NON-MATERIAL AMMENDMENT TO PLANNING PERMISSION 3/2020/0309 FOR THE ERECTION OF 34 DWELLINGS AND ASSOCIATED WORKS ON LAND AT SPOUT FARM, PRESTON ROAD, LONGRIDGE, PR3 3BE.

The applicant seeks the LPA's permission to amend Condition 2 of the planning permission. The changes relate to minor changes to details within plot numbers 4, 5, 6, 7, 8, 14, 20 and 28. Submitted with the NMA are the following house type plans to illustrate the proposed changes:

Planning
Ashton-As-1026sqft

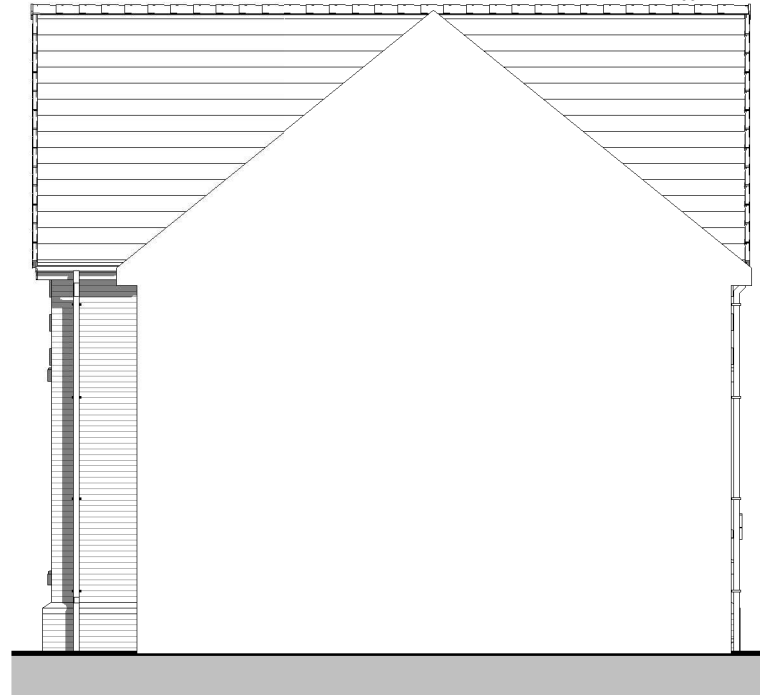
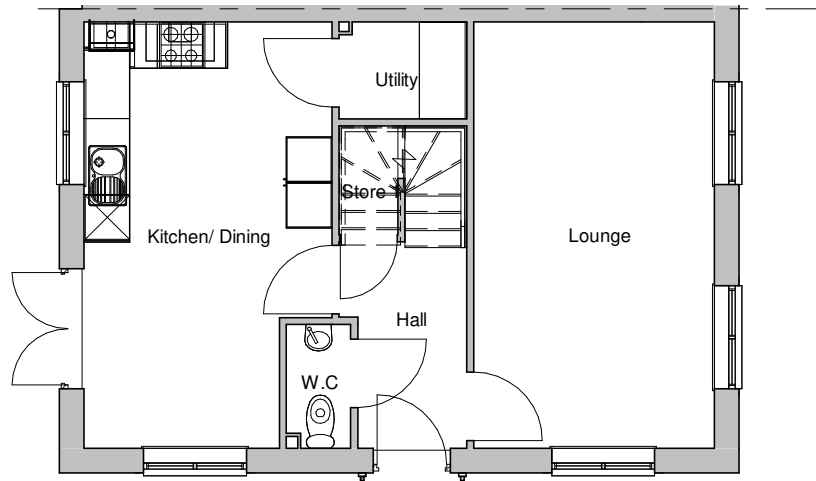
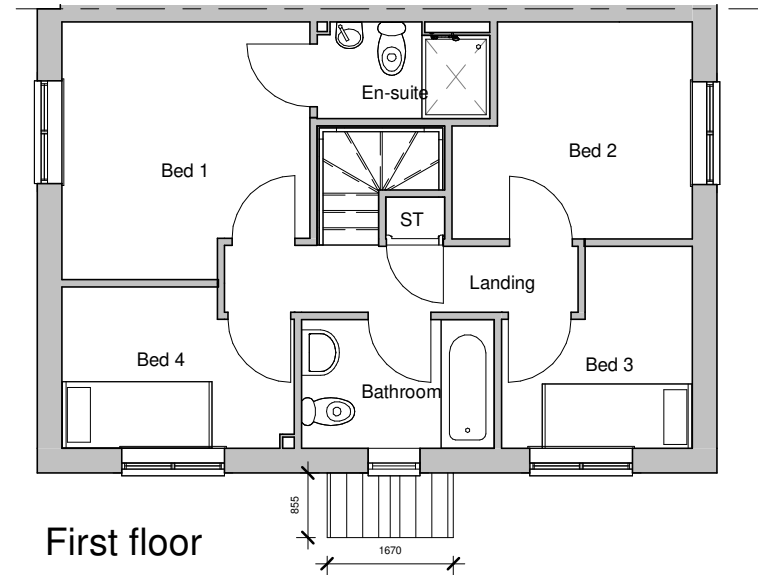
The proposals seek to replace the approved house type named 'New Four Bed Detached' (Drawing no. 19-133 HT4BD Rev C) with the revised house type named 'Ashton' (Drawing no. 19-133-ASH-AS-001-A).

The change proposed relates to the addition of a pitched roof porch detail to the property's front door. This amendment is considered to enhance the front elevation of the properties over the approved porch design, introducing an attractive feature to improve the street scene.

Client: createhomes.	Project: Core House Types	Drawing Title: Planning Larches-As-832sqft	Drawn: CE	Checked: SK	Scale (A3) : 1 : 100	Date: JULY 2020
			Drawing No: LA-AS-001	Job No: 19-133	Rev: A	
CONSTRUCTION

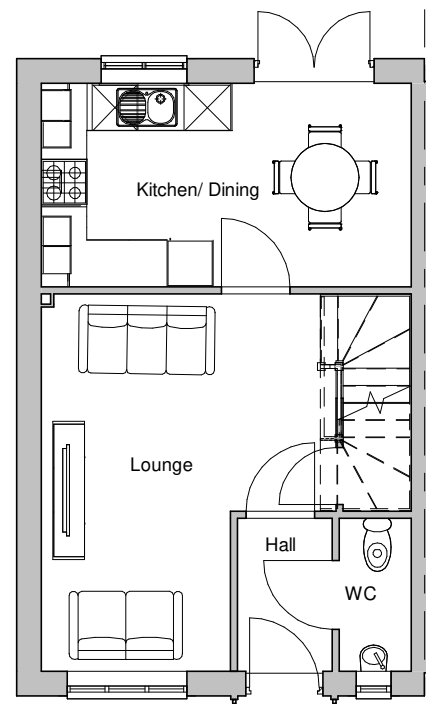
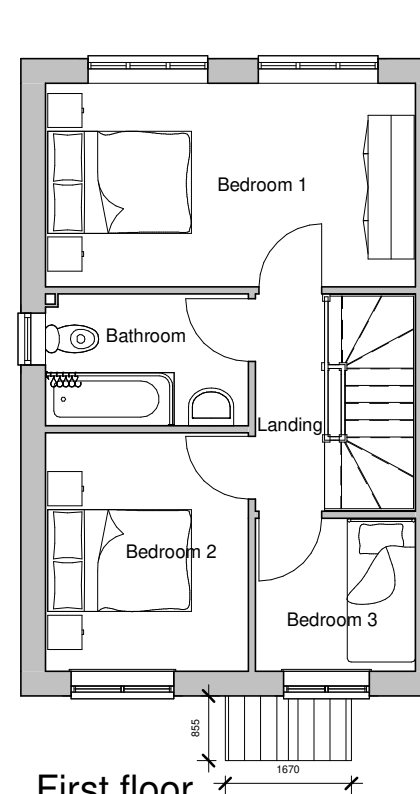
The proposals seek to replace the approved house type named 'Churchtown' (Drawing no. 19-133 CHU Rev C) with the revised house type named 'Larches' (Drawing no. 19-133-LA-AS-001-A).

The only change proposed to the house type is the addition of a pitched roof porch detail to each of the property's front doors. This amendment is considered to enhance the front elevation of the properties over the approved porch design, introducing an attractive feature to improve the street scene.

Planning
Cadley-AS-1079sqft

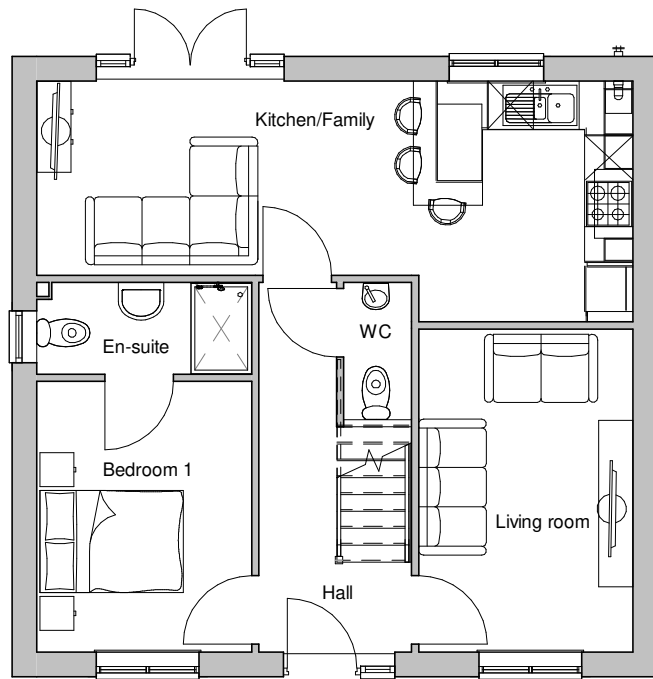
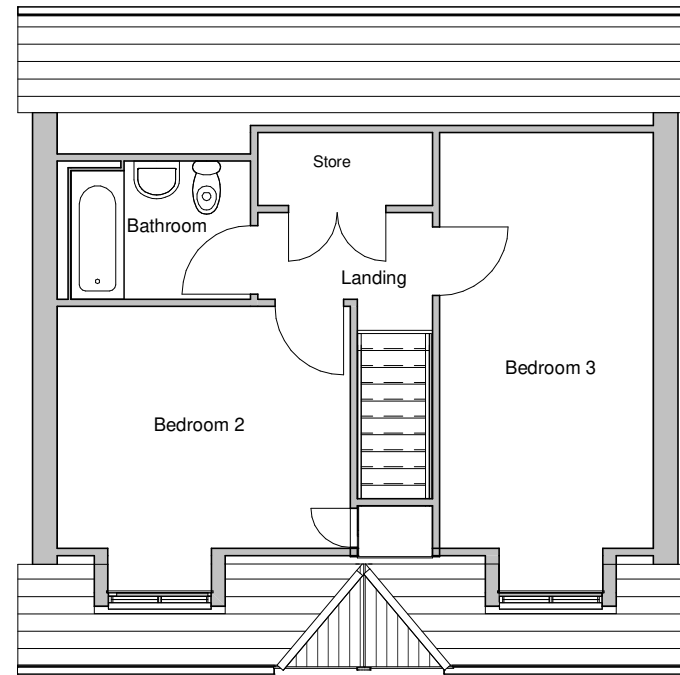
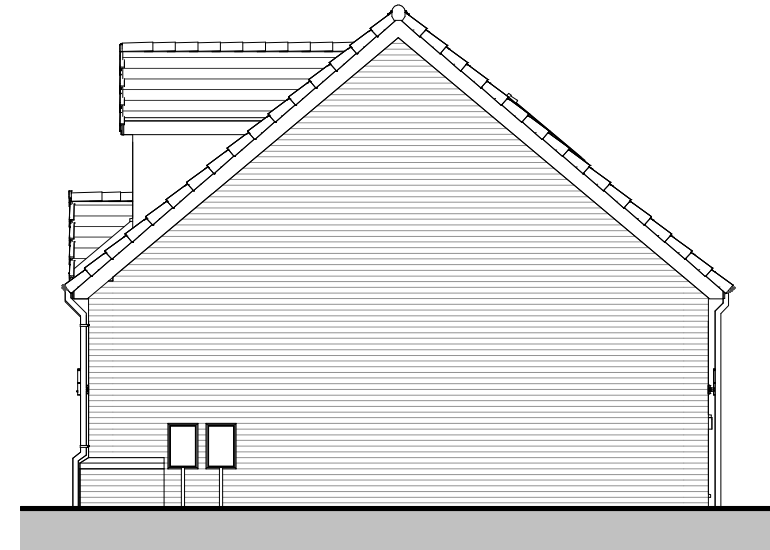
The proposals seek to replace the approved house type named 'New 3 Bed Bungalow' (Drawing no. 19-133 HT3BB Rev E) with the revised house type named 'Cadley' (Drawing no. 19-133-CAD-AS-001-B).

The change proposed relates to the addition of a pitched roof detail above the property's front doors. This amendment is considered to enhance the front elevation of the property over the approved design, introducing an attractive feature to improve the street scene.

Client: 	Project: Core House Types Farringdon-AS-2066sqft	Drawing Title: Planning	Drawn: GO	Checked: SK	Scale: 1 : 100	Date: JULY 2020
			Job No: 19-133	Drawing No: FA-AS-001	Rev: A

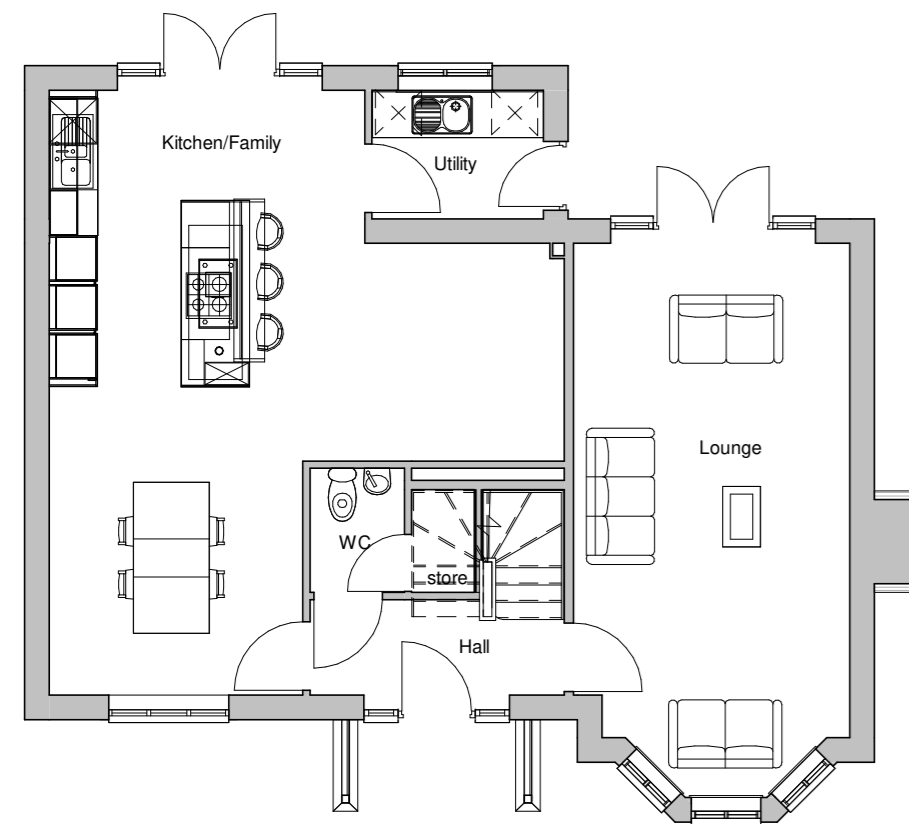
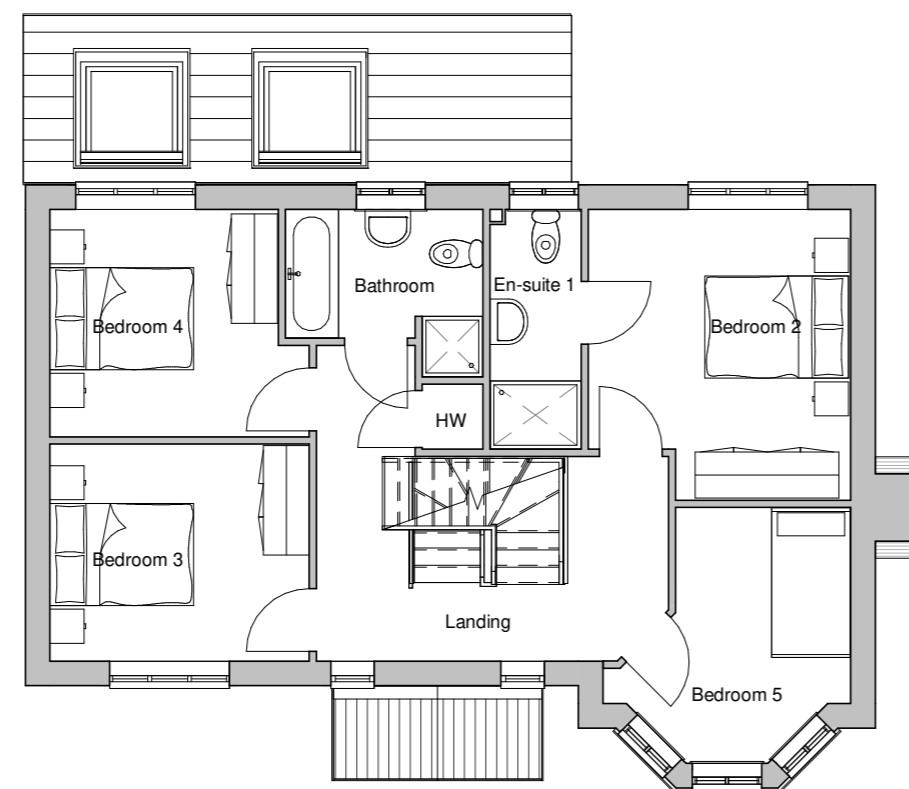
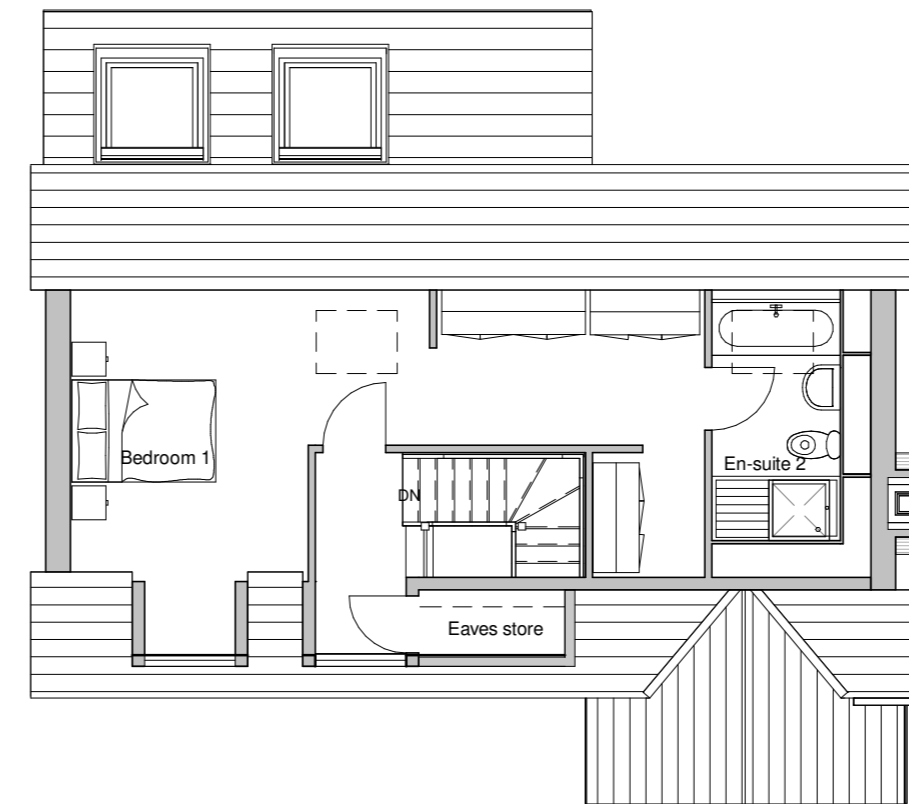
The proposals seek to replace the approved house type named 'Sowerby' (Drawing no. 19-133 SOW-E Rev D) with the revised house type named 'Farringdon' (Drawing no. 19-133-FA-AS-001-A).

The change proposed relates to the addition of timber cladding above the first-floor bay windows. This amendment is considered to enhance the front elevation of the properties over the approved design, introducing an attractive feature to improve the street scene.
